Notice of Exhibition – Moorebank Precinct West (MPW): Stage 2 Application SSD 7709

Reference is made to the ongoing discussions regarding the subject proposals. This is the combined response of Transport for NSW and Roads and Maritime Services (collectively referred to as TfNSW).

Annexure A – Summary of TfNSW concerns

Figure 4-1 – Proposed upgraded layout of the M5 Motorway / Moorebank Avenue interchange (based on the recommended improvements due to background traffic)

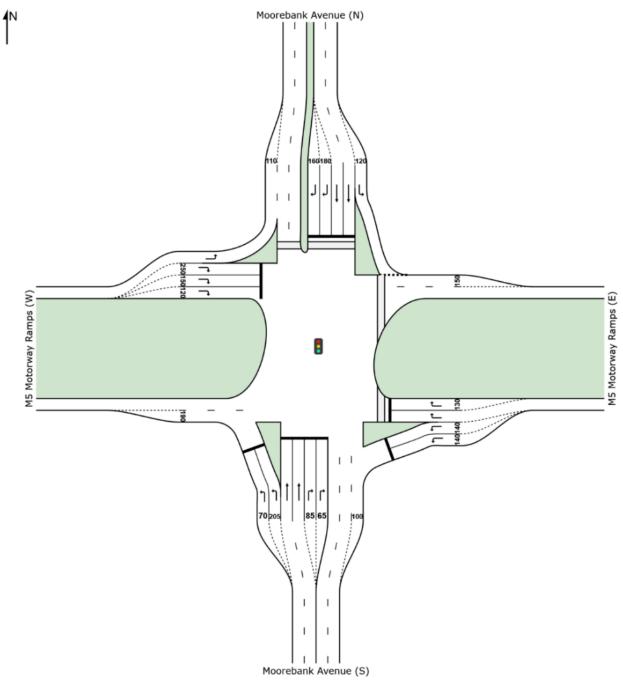
- V. M5 Motorway/Moorebank Avenue – the proponent states that widening of Moorebank Avenue to four lanes between the M5 Motorway/Moorebank intersection and Moorebank Avenue/Anzac Road intersection is required. Changes to the signals to vehicle actuation to improve performance of the west and north approaches are proposed. Upgrades to this intersection are also required to cater for the Proposal traffic to provide additional capacity on the westbound on-ramp, eastbound off-ramp, and increased storage lengths of the existing (two-lane) right turn bay on Moorebank Avenue northern approach. Further details regarding these upgrade works is required.
